Marine Management Organisation

DCO/2017/00003

22 February 2019

THE PLANNING ACT 2008 - SECTION 89 AND THE INFRASTRUCTURE PLANNING (EXAMINATION PROCEDURE) RULES 2010: LAKE LOTHING THIRD CROSSING, LOWESTOFT ORDER – DEADLINE 5, ISSUE SPECIFIC HEARING 1

Drawing file: TR010023 / TR010023-001017-Suffolk County Council - Limits of Dredging.pdf

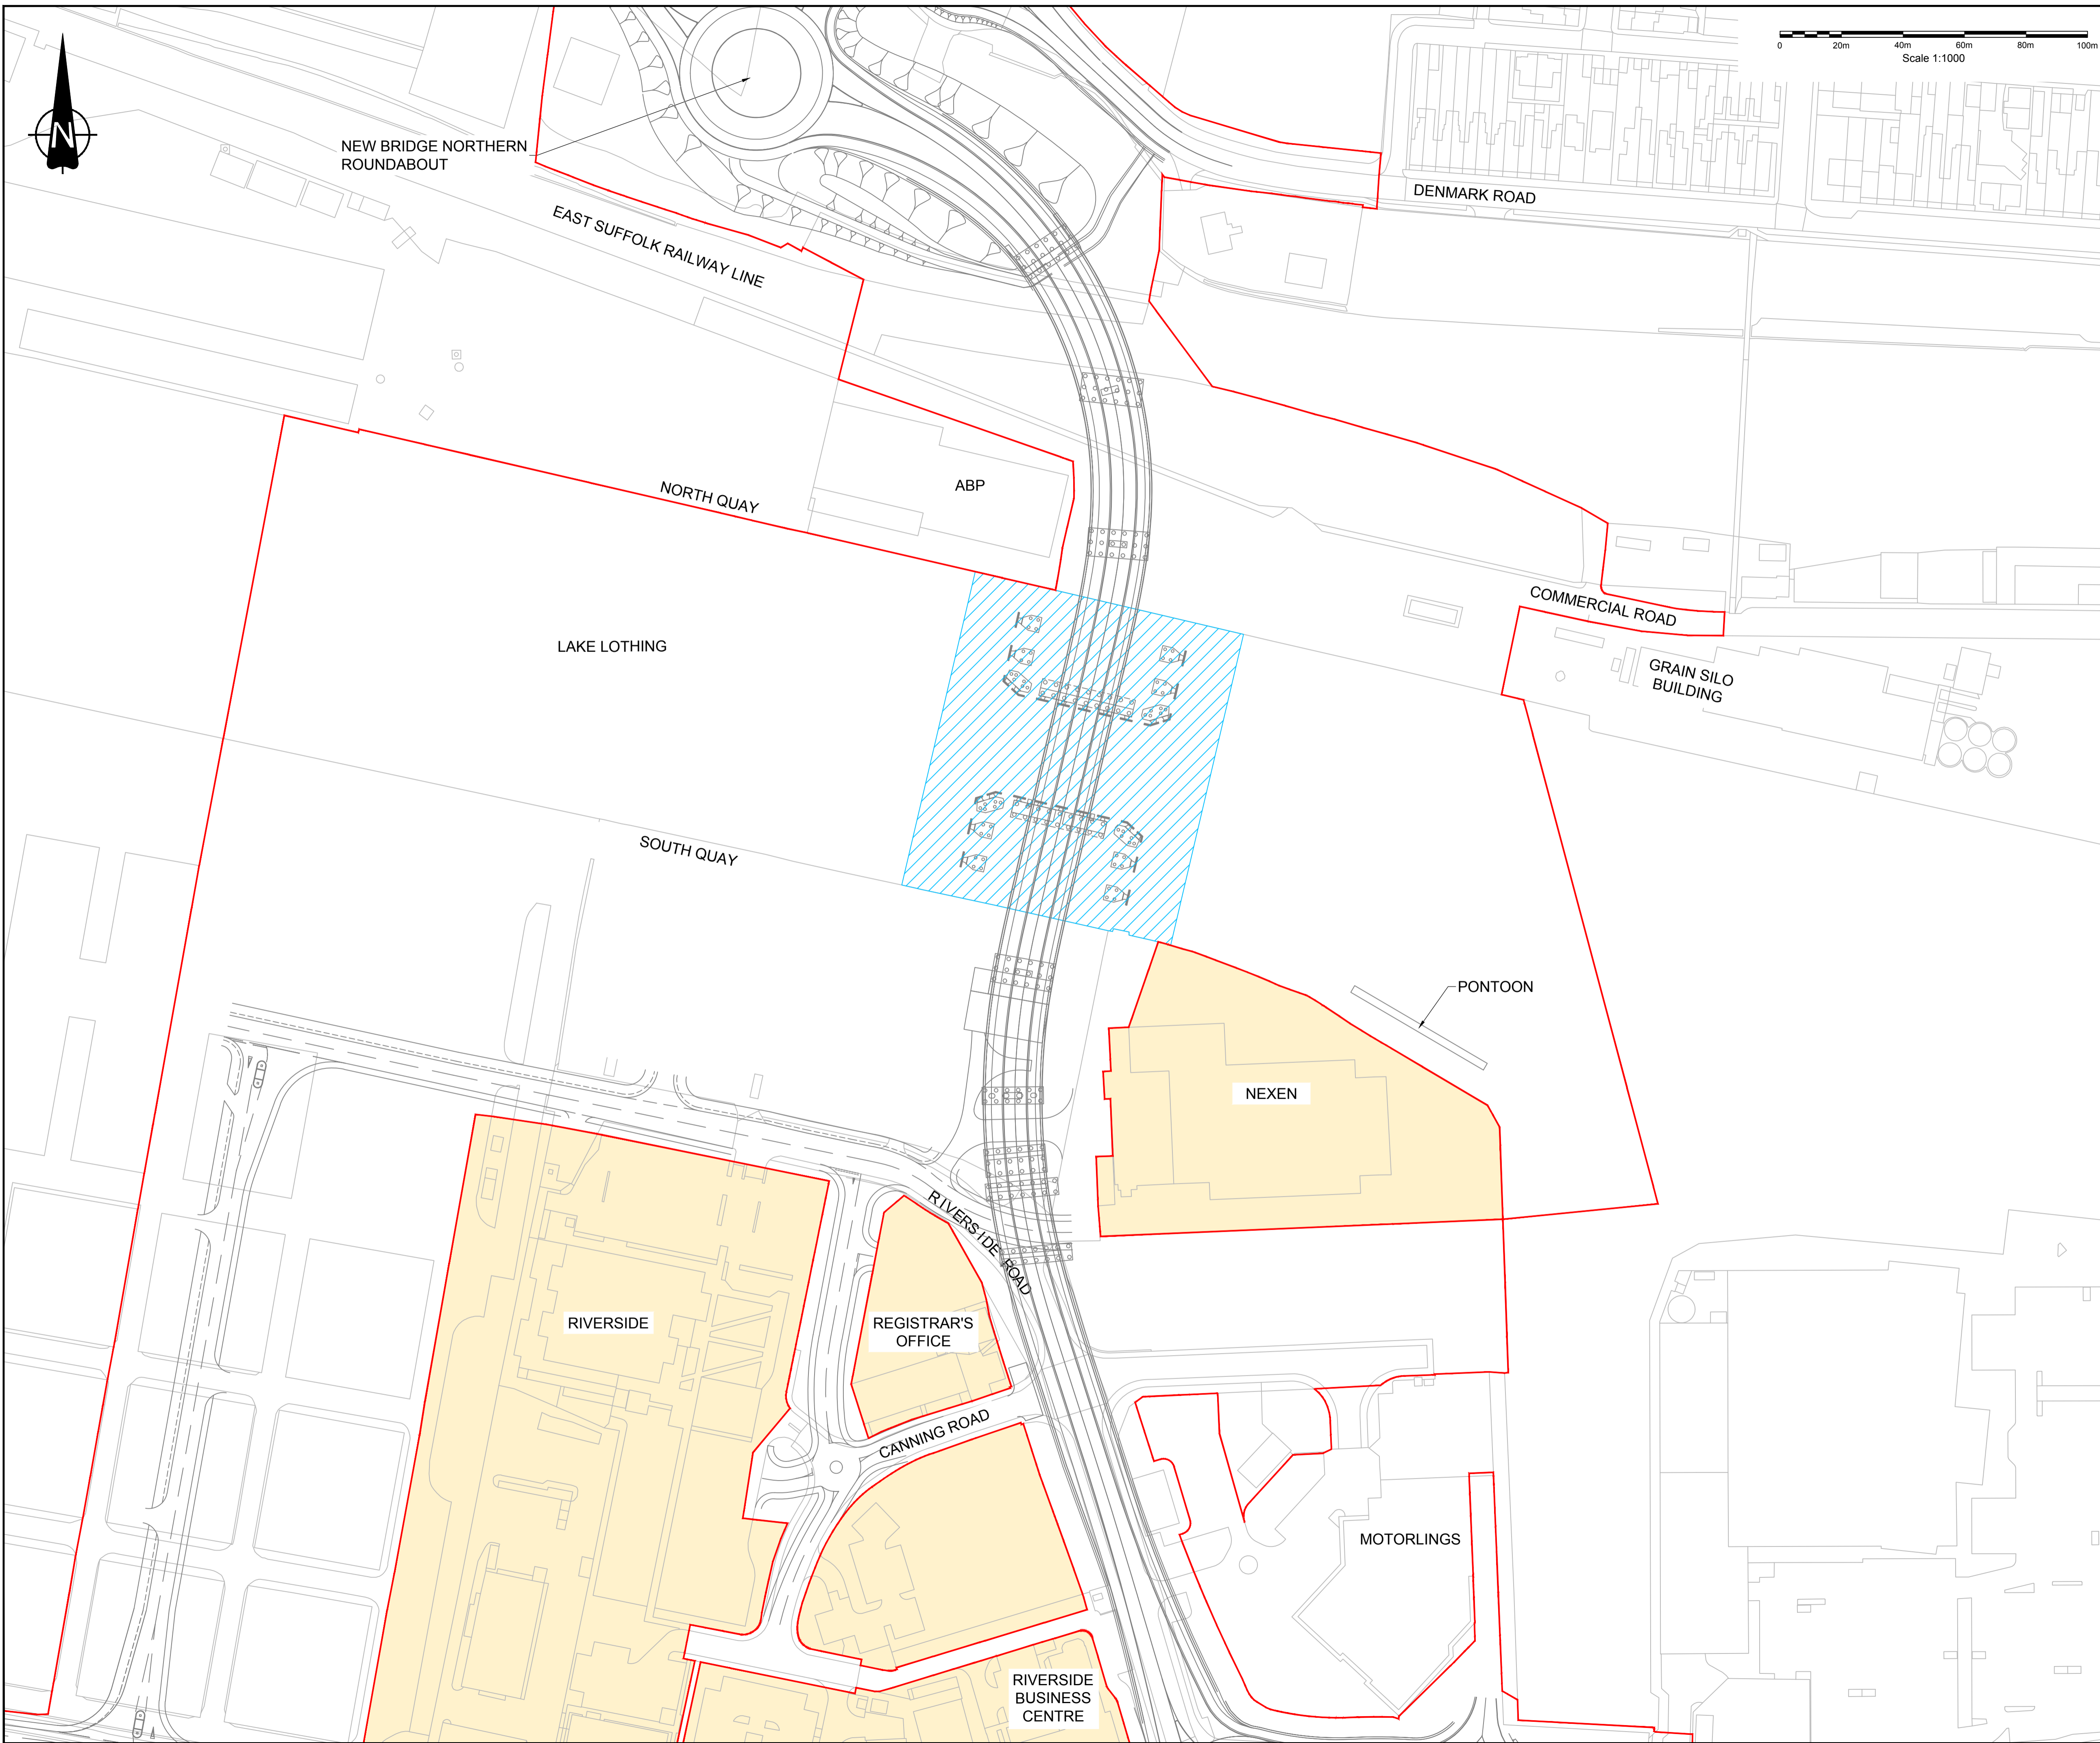
2.3.1 Under **Part 2(5)** of the DCO, reference is made to the "Limits of Deviation". The MMO notes that this article does not appear to reference the limits of the dredging area. Specifically, the limits of deviation do not appear to account for, or reference, intended depths to which material will be dredged. The MMO advises that this information must be presented for dredging activities to be undertaken, under the DCO.
